# Agency Review Comments

Homestead at Sterling Ranch 2A and Sterling Ranch Fling 1A VR

VR234

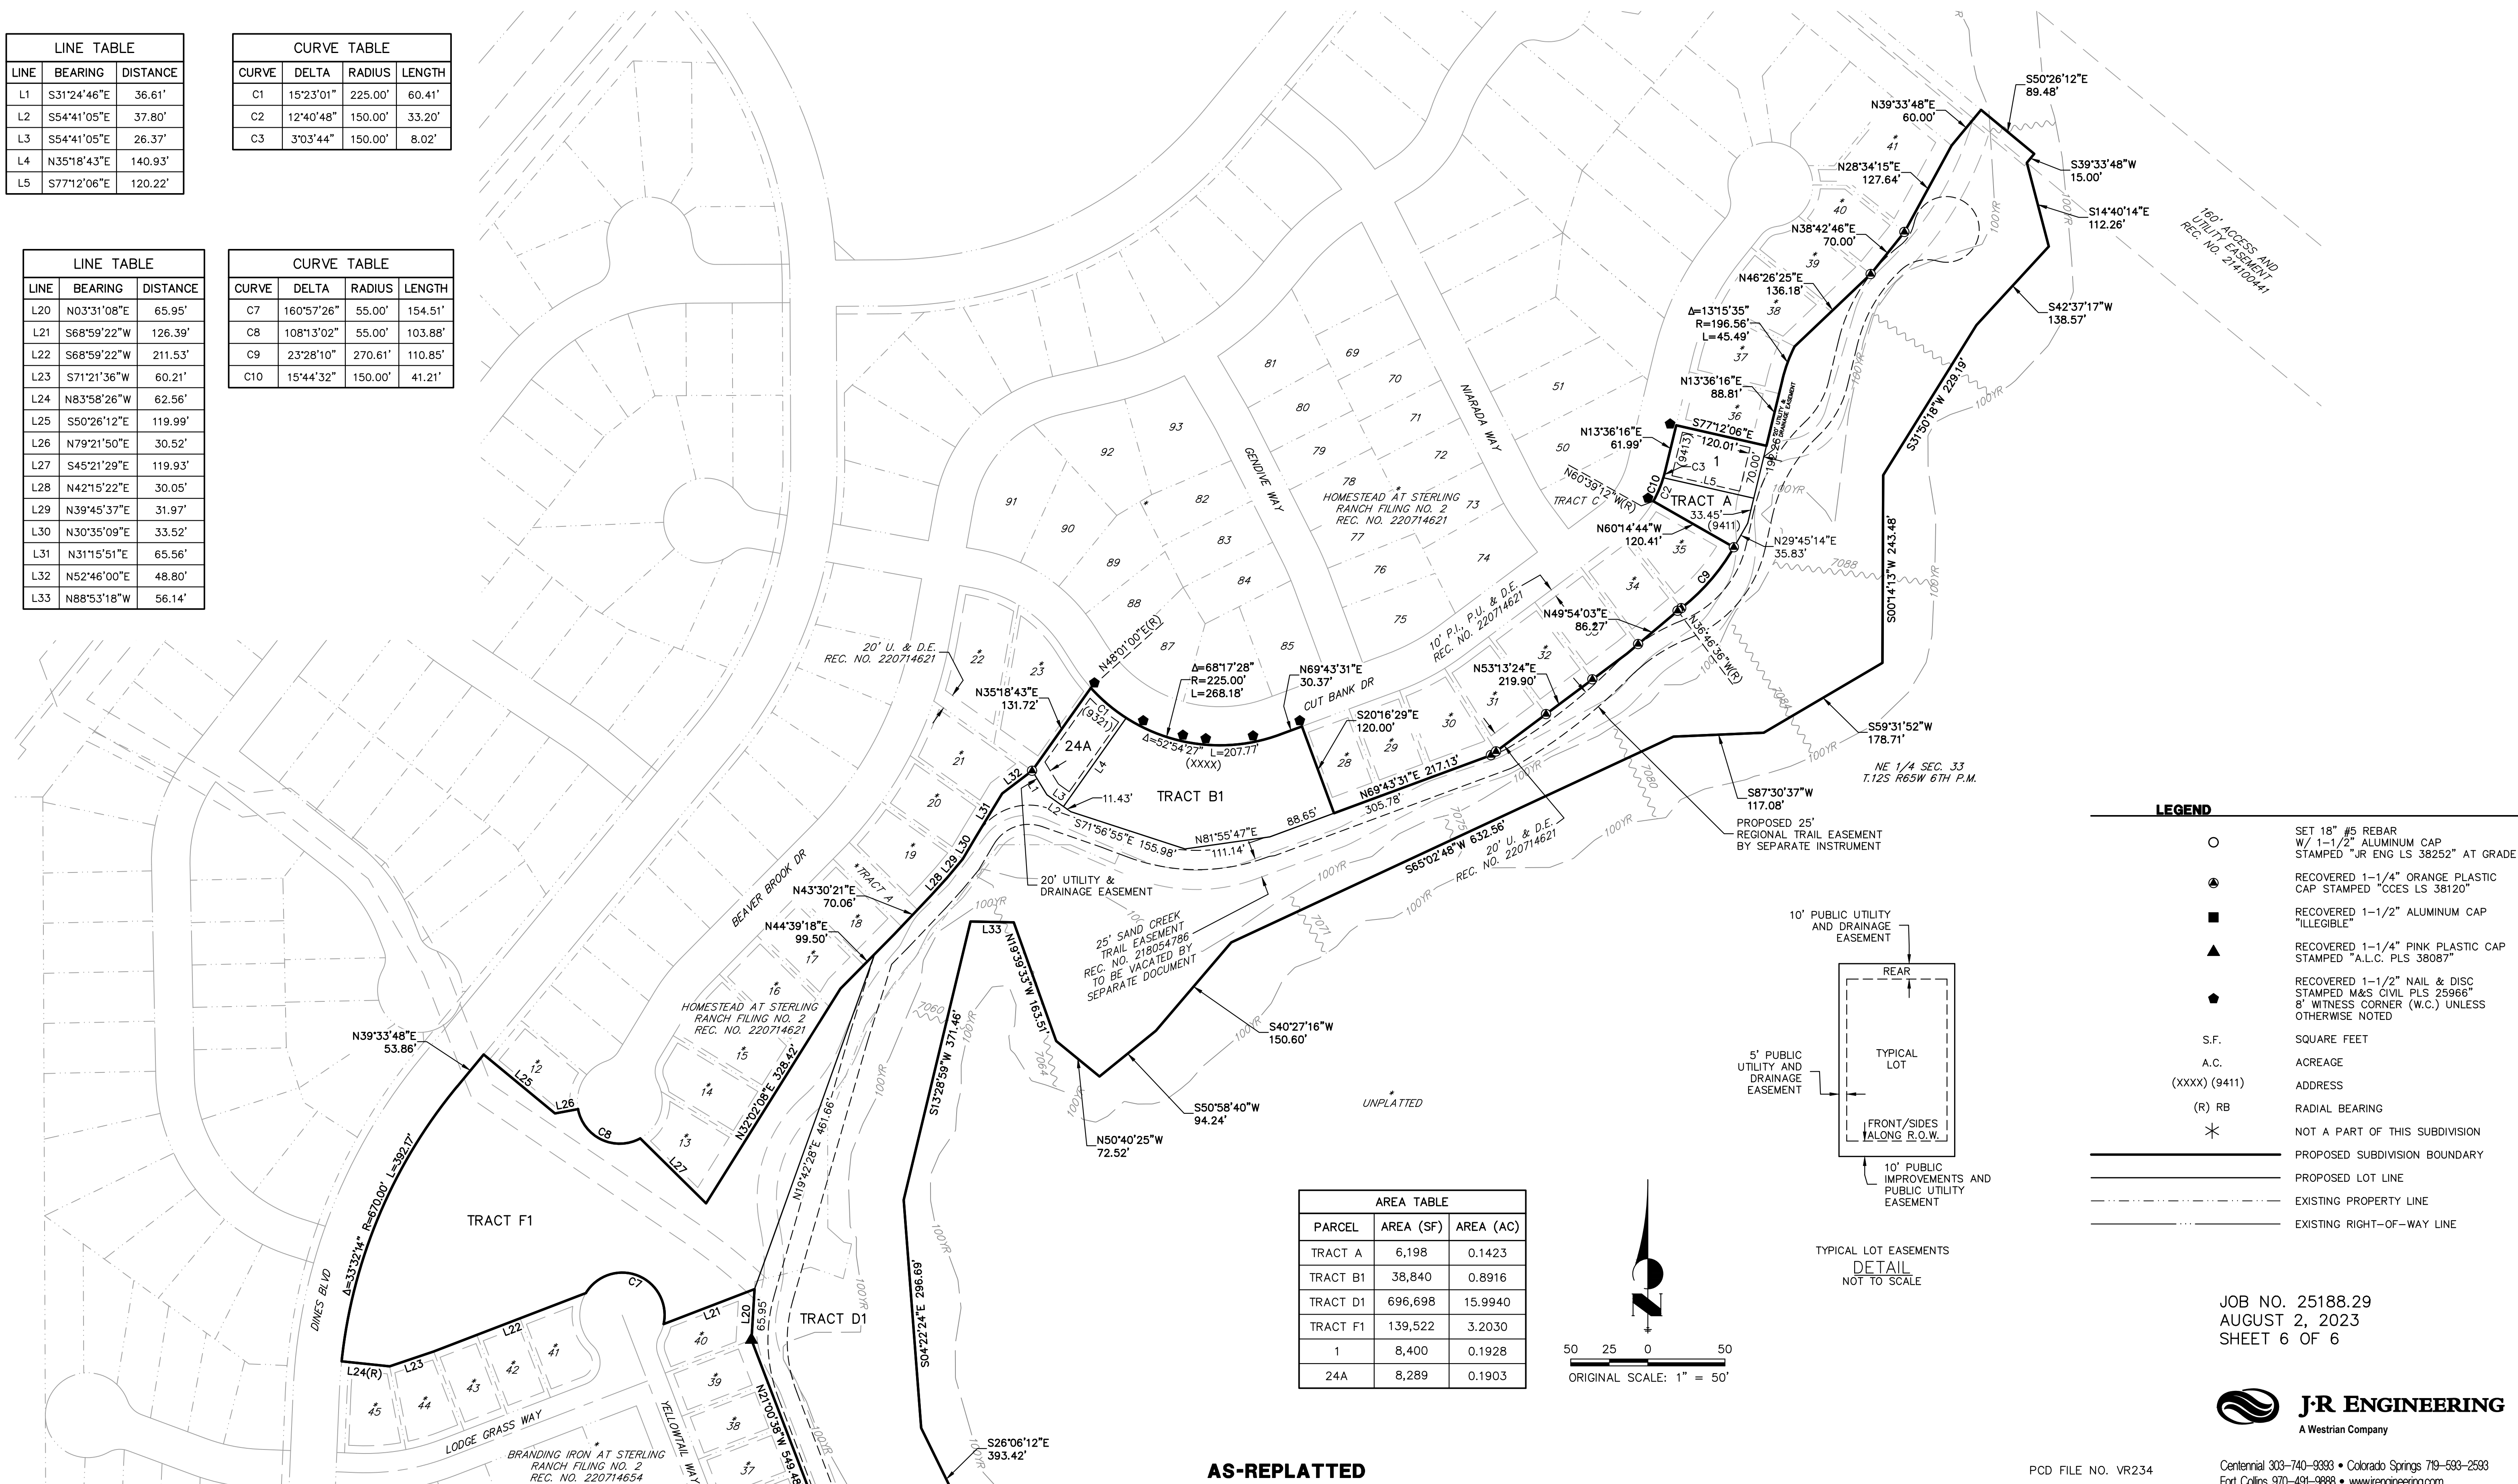
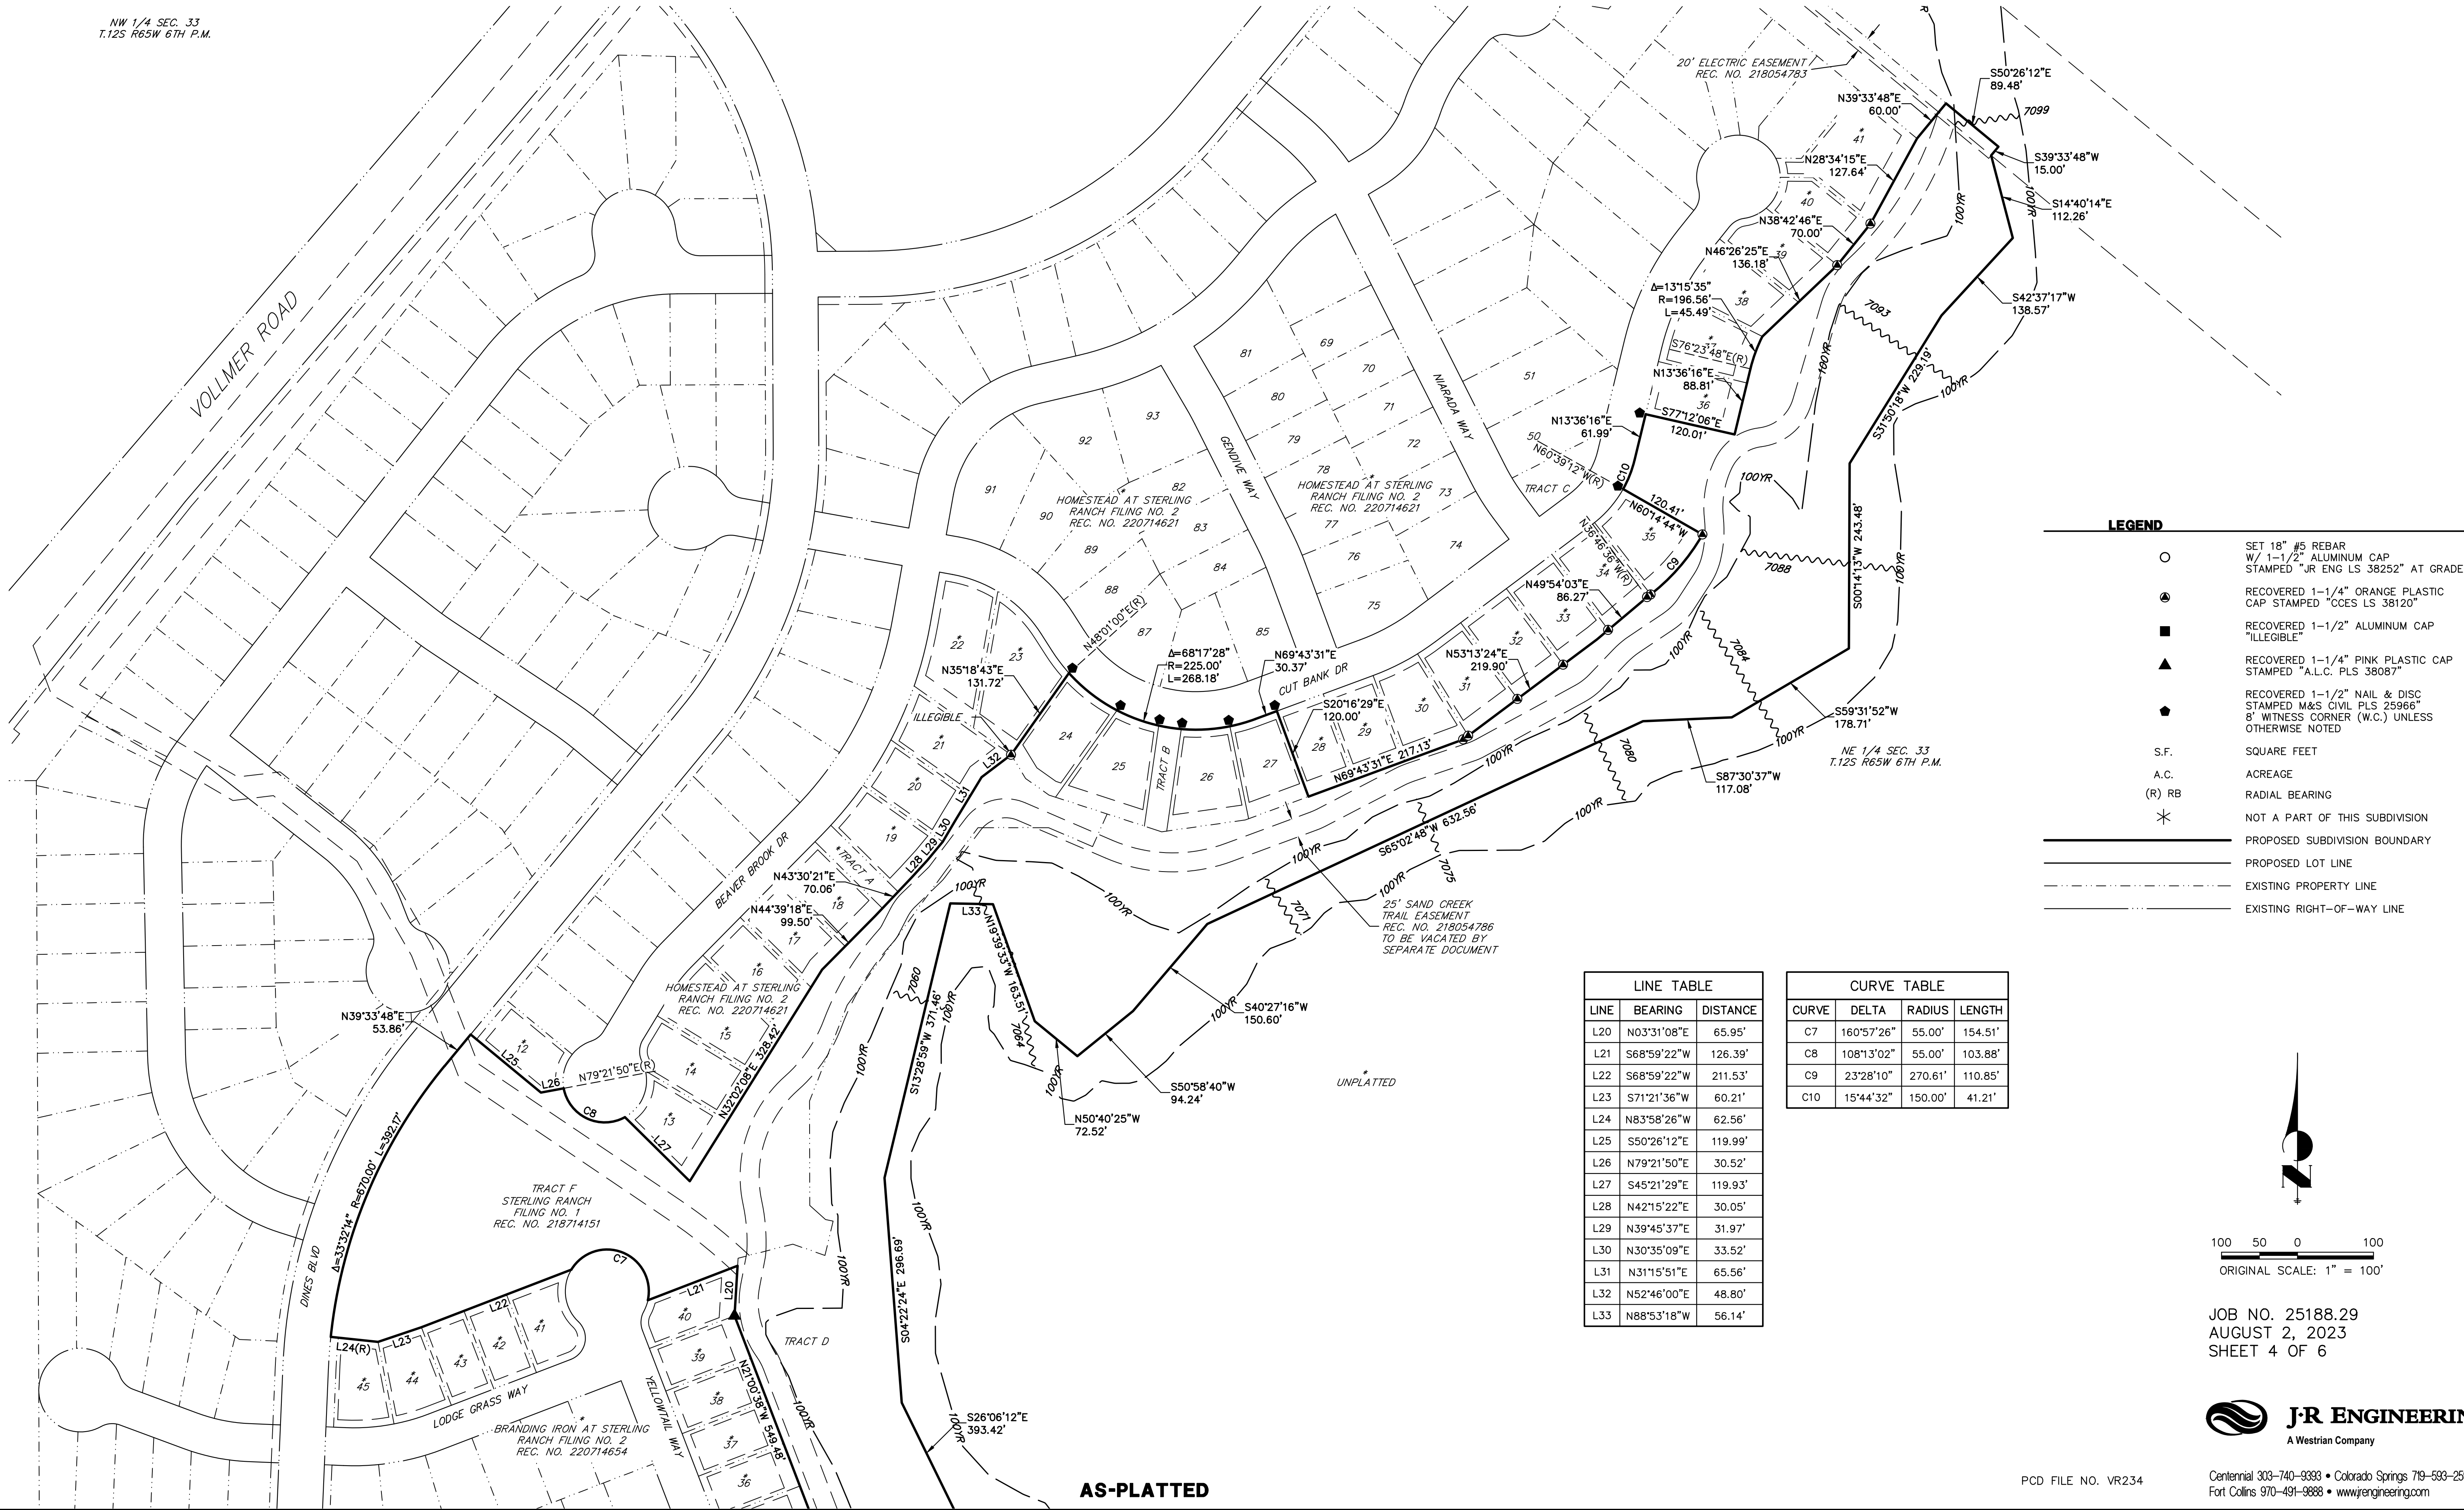
Agency	Comment	Date
PCD Project Manager	thicken the linework (as depicted in the closure sheets) as replatted area tract and as replatted lot lines so its clear that they are being redefined with this plat. Lot 24a and lot 1 are very hard to differentiate from the existing platted lots not included, as are the new tracts. <b>ADDRESSED</b>	7/18/2023 2:52:50 PM
PCD Project Manager	Please label what is to be vacated for trail and maintenance easements in tract and what is to remain or be dedicated as trail easements or maintenance tracts. <b>THE 25' SAND CREEK TRAIL EASEMENT IS LABELED AS "TO BE VACATED BY SEPARATE INSTRUMENT" AND "BY SEPARATE INSTRUMENT" HAS BEEN ADDED TO THE REGIONAL TRAIL EASEMENT LABEL.</b>	7/18/2023 2:48:10 PM
PCD Engineering Division	EPC Engineering has no further comments.  Reviewed by: Charlene Durham charlenedurham@elpasoco.com	7/18/2023 2:27:27 PM
EPC Stormwater Review	EPC DPW Stormwater has no further comments.	7/10/2023 5:22:34 PM
